CITY OF PORTLAND BUILDING PERMIT

97 NEWBURY ST

PERMIT ID: 2013-00759

has permission to **Build 2nd floor balcony - 15'9" x 6'**

Newburn St Balcony

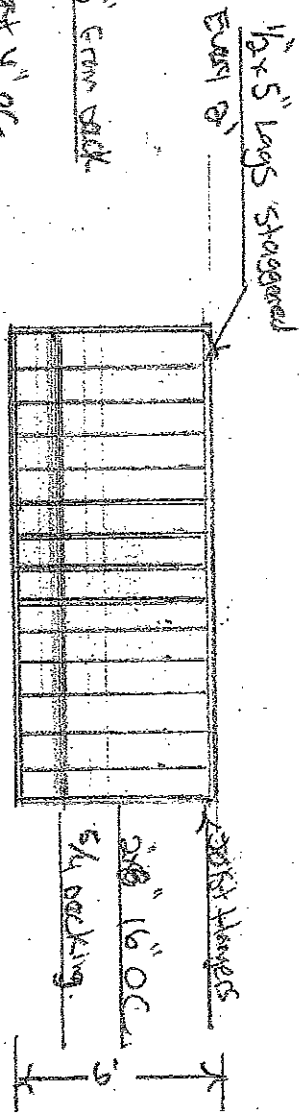
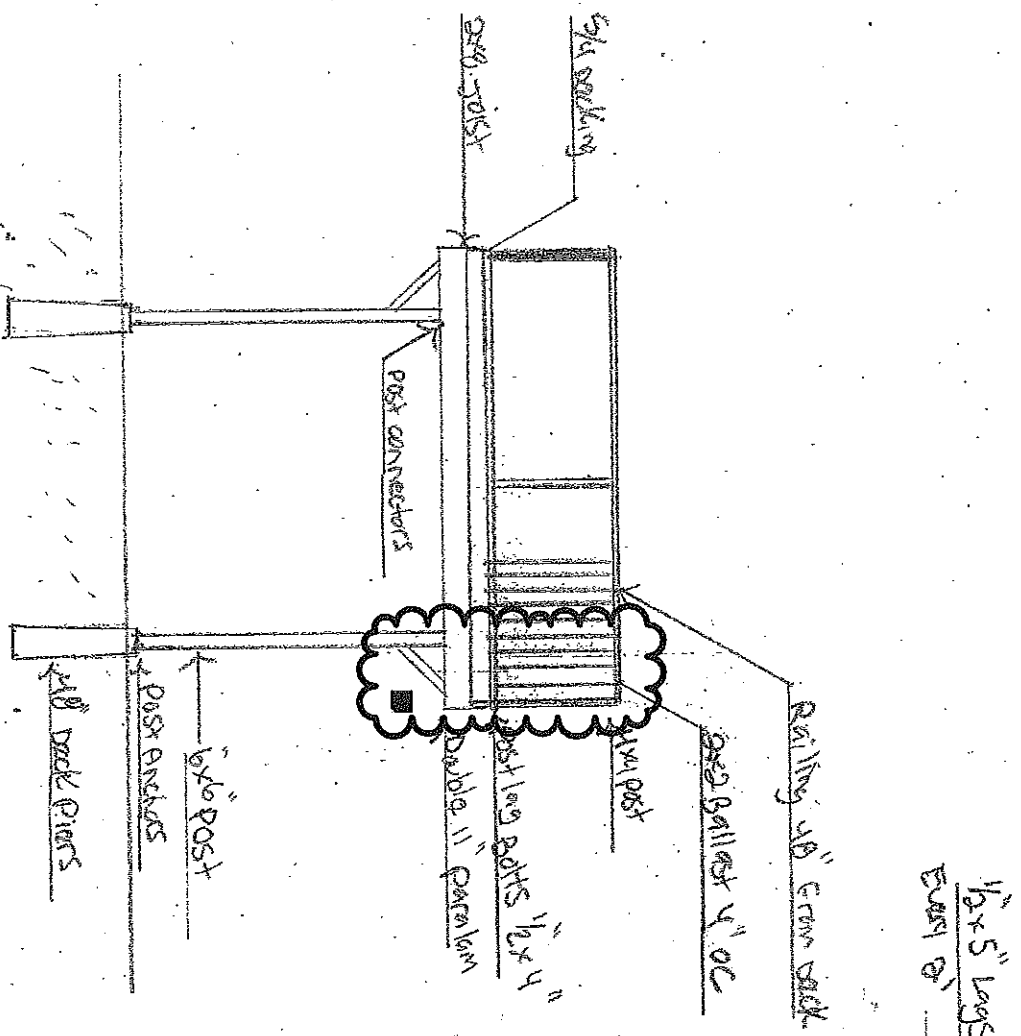
City of Portland, Maine - Building or Use Permit		Permit No: 2013-00759	Date Applied For: 04/18/2013	CBL: 020 B017001
389 Congress Street, 04101 Tel: (207) 874-8703, Fax: (207) 874-8716				
Proposed Use: 1st floor personal service & office- 2nd floor dwelling unit, 3rd floor vacant		Proposed Project Description: Build 2nd floor balcony - 15'9" x 6'		
Dept: Zoning	Status: Approved	Reviewer: Ann Machado	Approval Date: 05/02/2013	Ok to Issue: <input checked="" type="checkbox"/>
Note:				
Dept: Building	Status: Approved w/Conditions	Reviewer: Jon Rioux	Approval Date: 05/24/2013	Ok to Issue: <input checked="" type="checkbox"/>
Note:				
<ol style="list-style-type: none"> 1) Separate permits are required for any electrical, plumbing, sprinkler, fire alarm, HVAC systems, heating appliances, including pellet/wood stoves, commercial hood exhaust systems and fuel tanks. Separate plans may need to be submitted for approval as a part of this process. 2) Separate permits are required for any electrical: plumbing, sprinkler, fire alarm, HVAC systems, commercial hood exhaust systems and fuel tanks. Separate plans may need to be submitted for approval as a part of this process. 3) Connections and Fasteners to be installed per 2009 IBC Sec. 234.9. 4) The guardrail system shall meet the loading requirements of section 1607.7.1 of the IBC 2009 (MUBEC) Building Code. 5) The design load spec sheets for any engineered beam(s) must be submitted to this office. 6) 1604.8.3 Decks. Where supported by attachment to an exterior wall, decks shall be positively anchored to the primary structure and designed for both vertical and lateral loads as applicable. Such attachment shall not be accomplished by the use of toenails or nails subject to withdrawal. Where positive connection to the primary building structure cannot be verified during inspection, decks shall be self-supporting. Connections of decks with cantilevered framing members to exterior walls or other framing members shall be designed for both of the following: 1. The reactions resulting from the dead load and live load specified in Table 1607.1, or the snow load specified in Section 1608, in accordance with Section 1605, acting on all portions of the deck. 2. The reactions resulting from the dead load and live load specified in Table 1607.1, or the snow load specified in Section 1608, in accordance with Section 1605, acting on the cantilevered portion of the deck, and no live load or snow load on the remaining portion of the deck.
